A47 DUALLING – NORTH TUDDENHAM TO EASTON

COMMENTS on behalf of A.C. MEYNELL of the [REDACTED]
on the Applicant's response to his Written Representations

Document reference: ACM 13

Date: 12 November 2021

DRAWING TITLE
DRAINAGE CATCHMENT PLAN

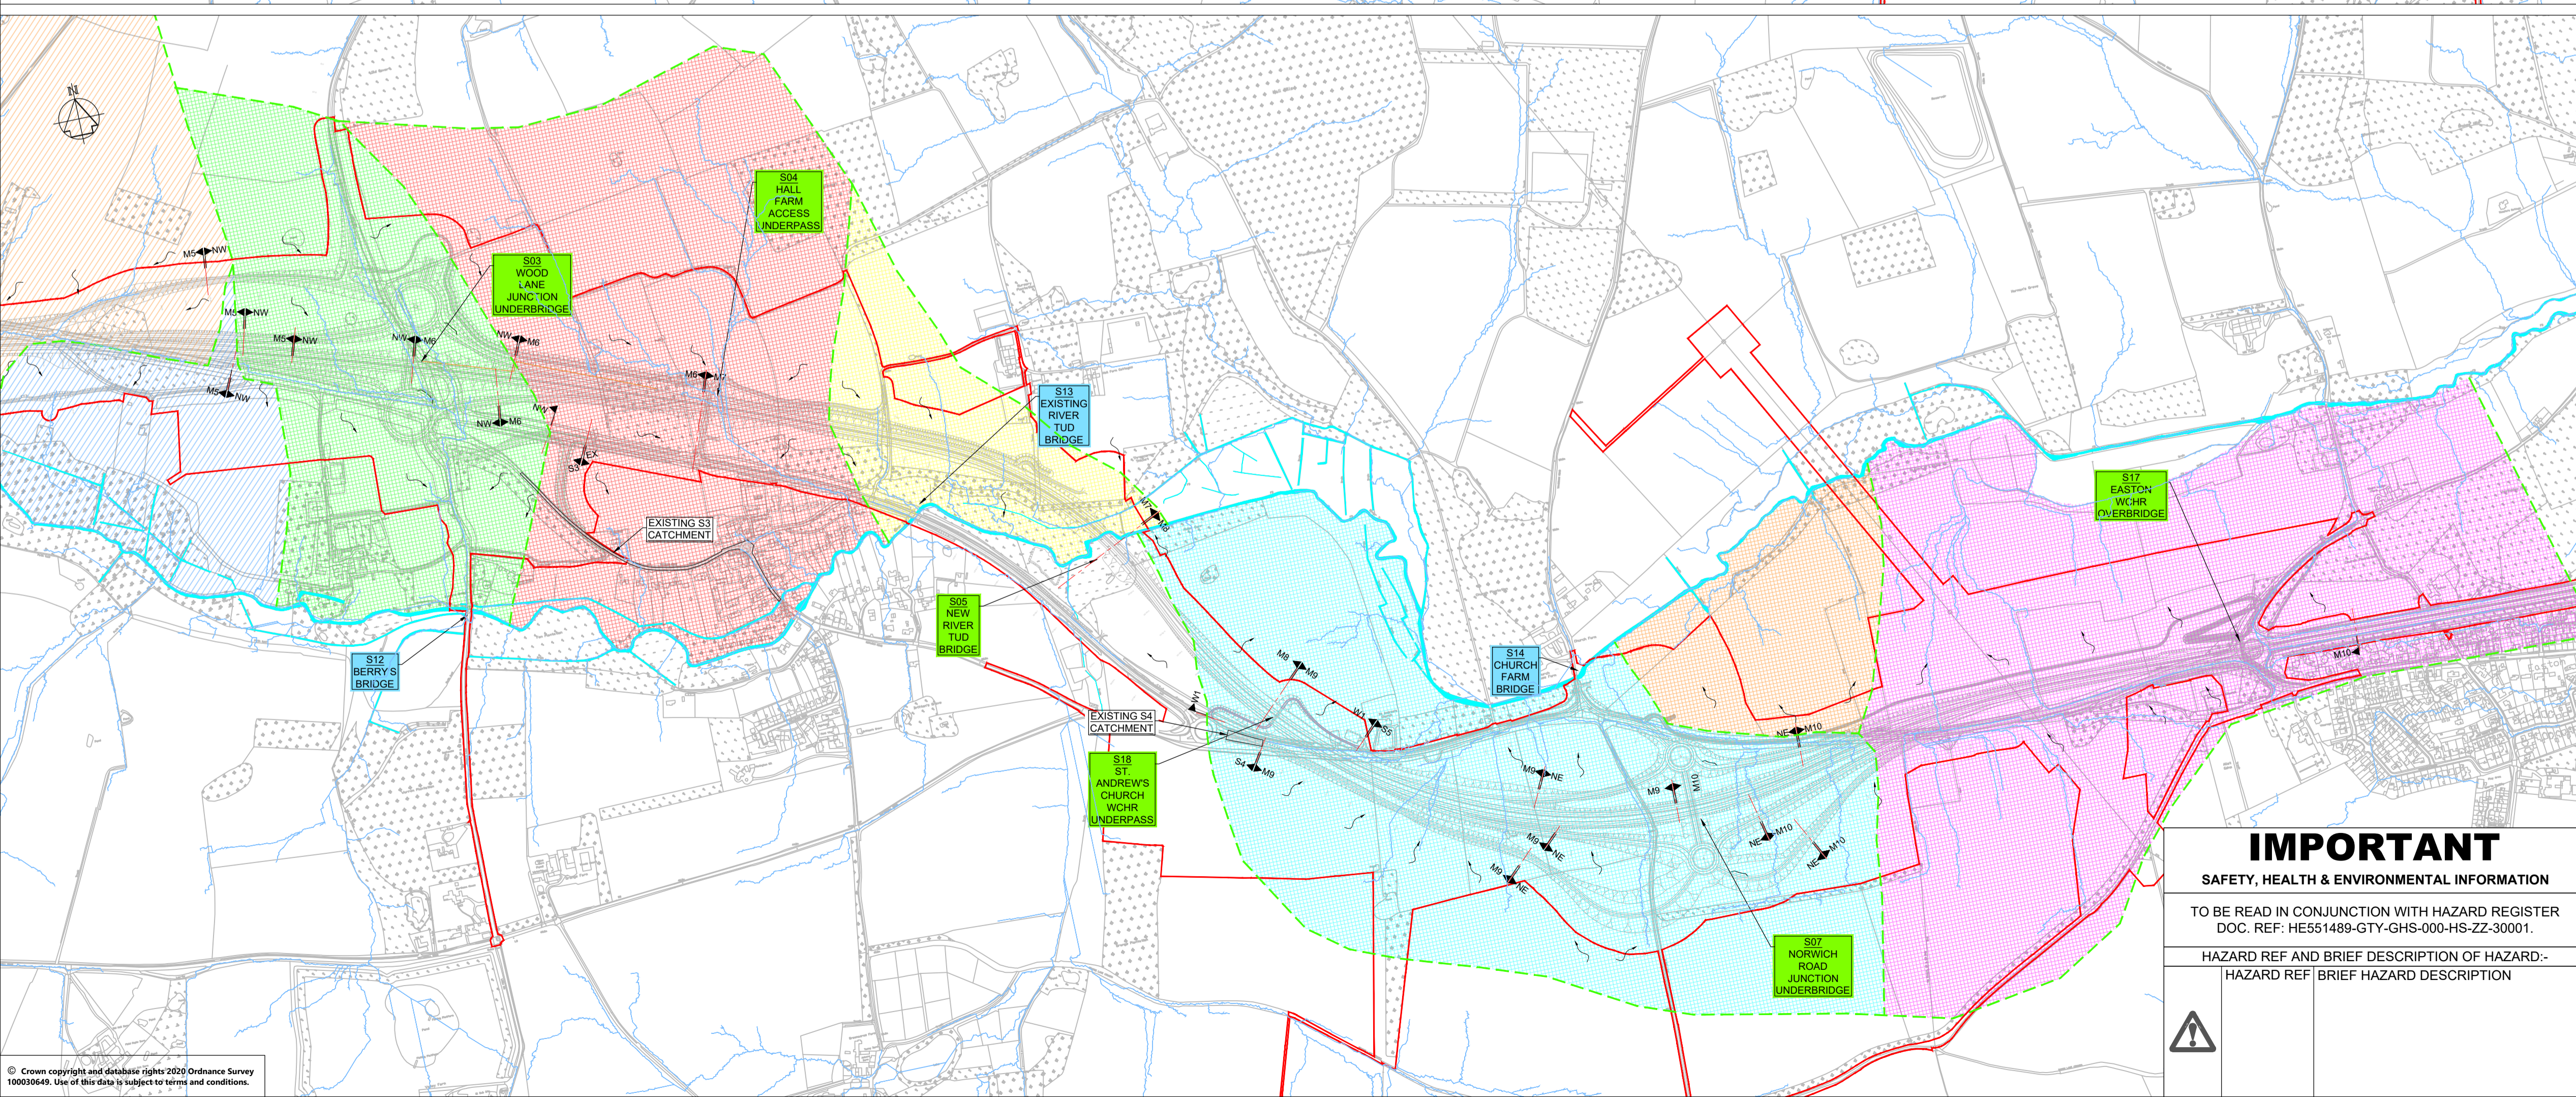
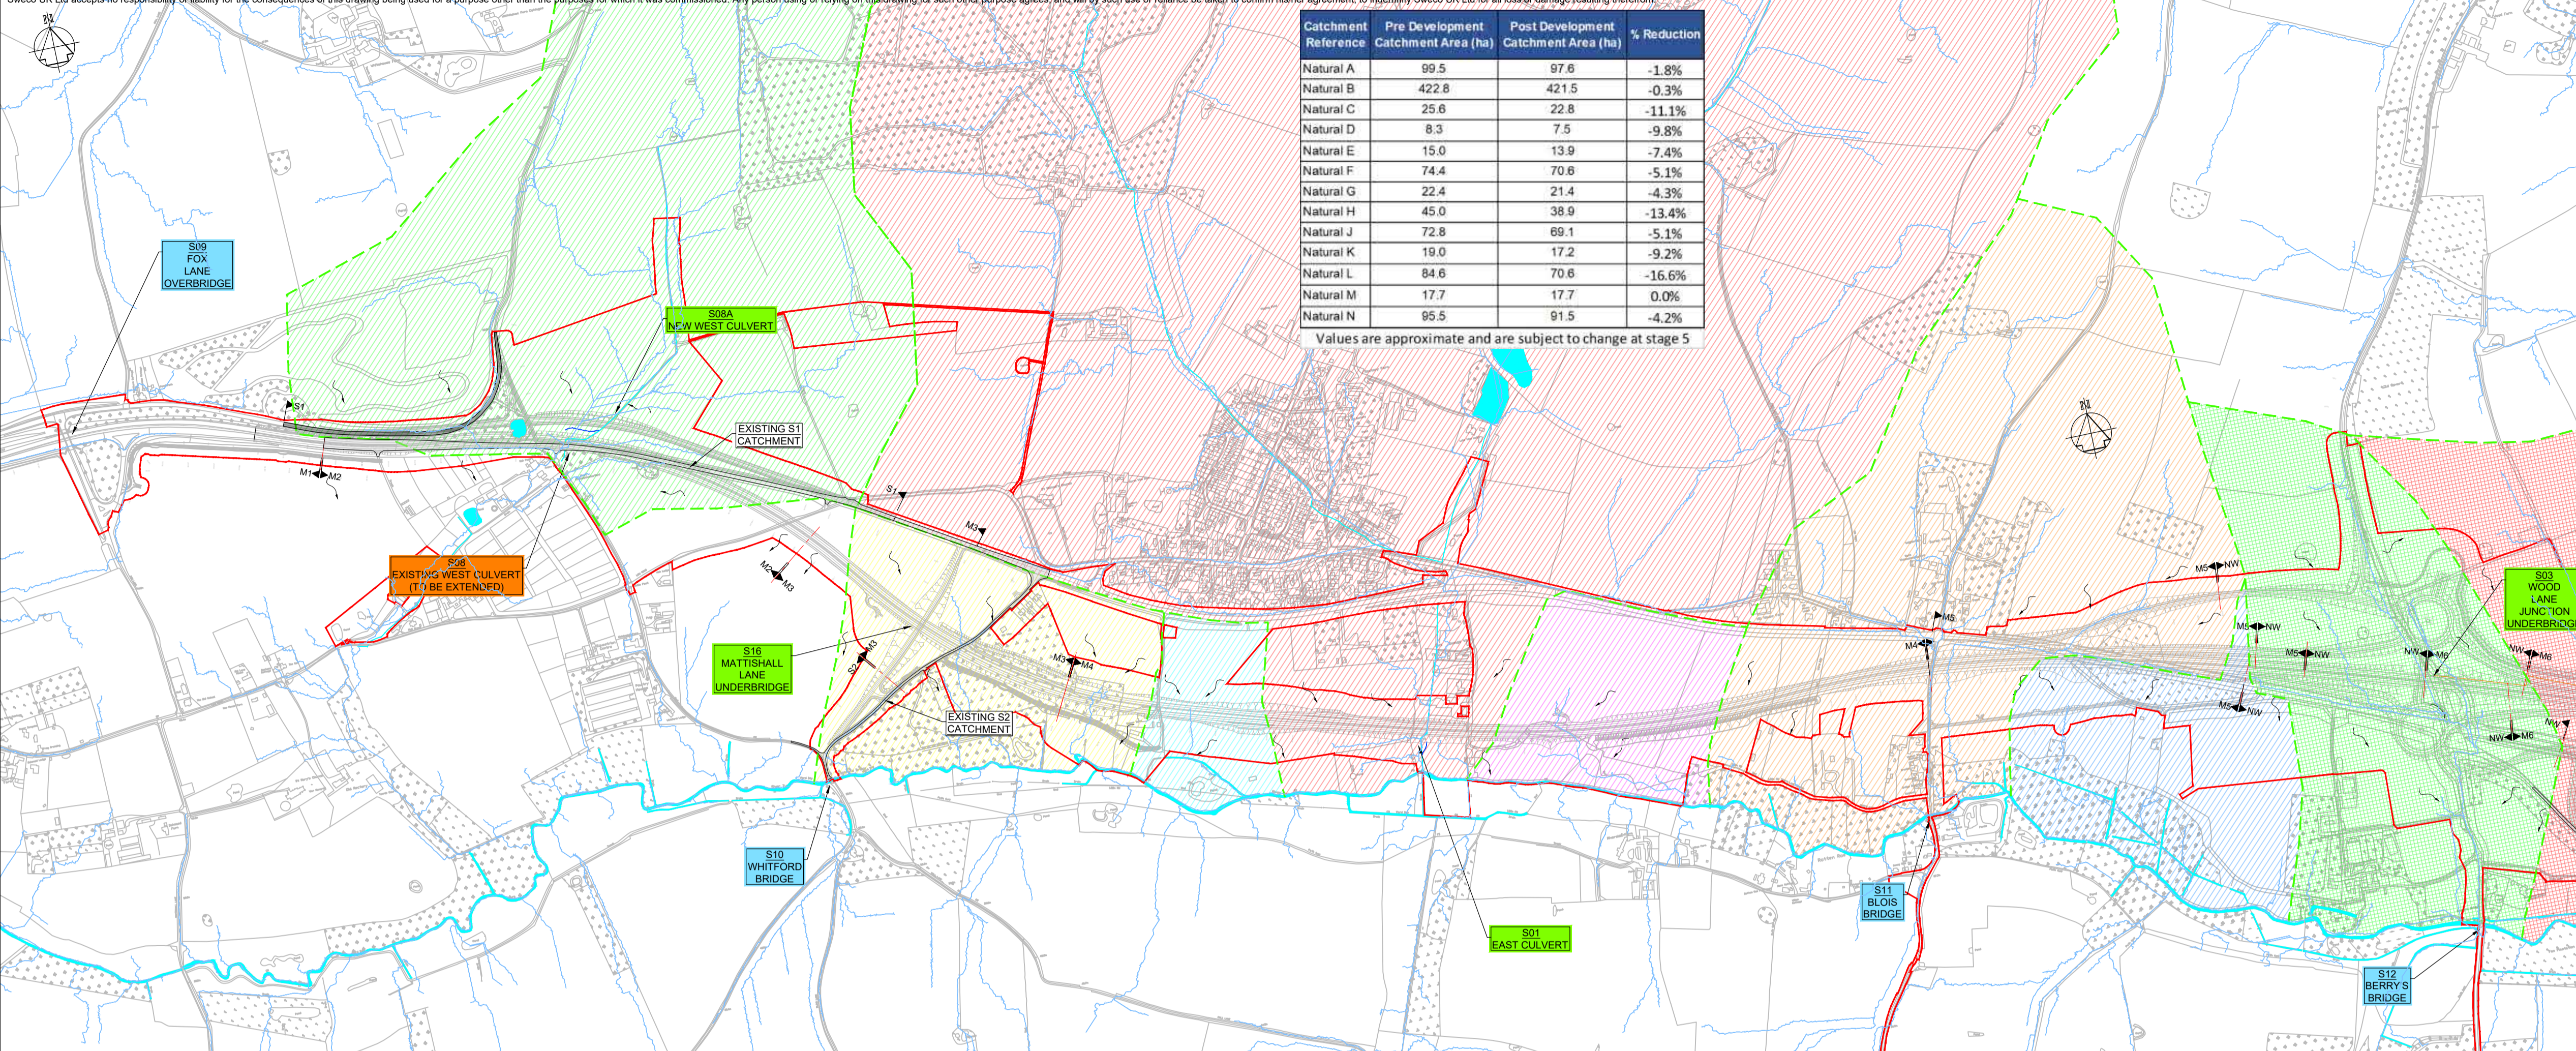
6.02.1		<p>Unless the proposed water run off into the River Tud upstream of Berry's Bridge is so constructed as to avoid the risk of causing flooding the Scheme is likely to cause a risk of damage to my land from flooding and a further adverse impact on access to the estate through the additional flood risk to Berry's Lane.</p>	<p>Flood risk is considered in ES Appendix 13.1 Flood Risk Assessment (APP-124 and APP-125). The Scheme includes mitigation measures that will ensure that the design is safe for its lifetime and will not detrimentally impact flood risk to others.</p>	<p>No details have been supplied as yet for the discharge into the River Tud or the ditch adjacent to it by Berry's Bridge.</p>

6.02.2			<p>A proposed pre earthworks ditch is required to provide a flow path for the land drainage ditches around the southern roundabout to an outfall at the River Tud. This is located parallel to the west side of Berrys Lane as shown on Sheet 9 of the Drainage & Surface Water Plans (APP-011). The proposed pre earthworks ditch will not be conveying any surface water run-off from the carriageway as this is contained within the piped network leading to the detention basin adjacent to the A47.</p>	<p>The ditch proposed will discharge as mentioned in the Comment at 6.02.1 above: does the Applicant have any estimates of the likely flow?</p>

6.02.3			<p>The final pre earthworks ditch will be designed in liaison with Norfolk County Council, as the Lead Local Flood Authority, and the Environment Agency as part of their consenting processes and Requirement 8 'Surface water drainage' of the dDCO (REP2-005). The design will be required to avoid increasing flood risk and includes allowances for increased rainfall due to climate change.</p>	<p>What proposals are being considered for the discharge at present? None have been supplied.</p>
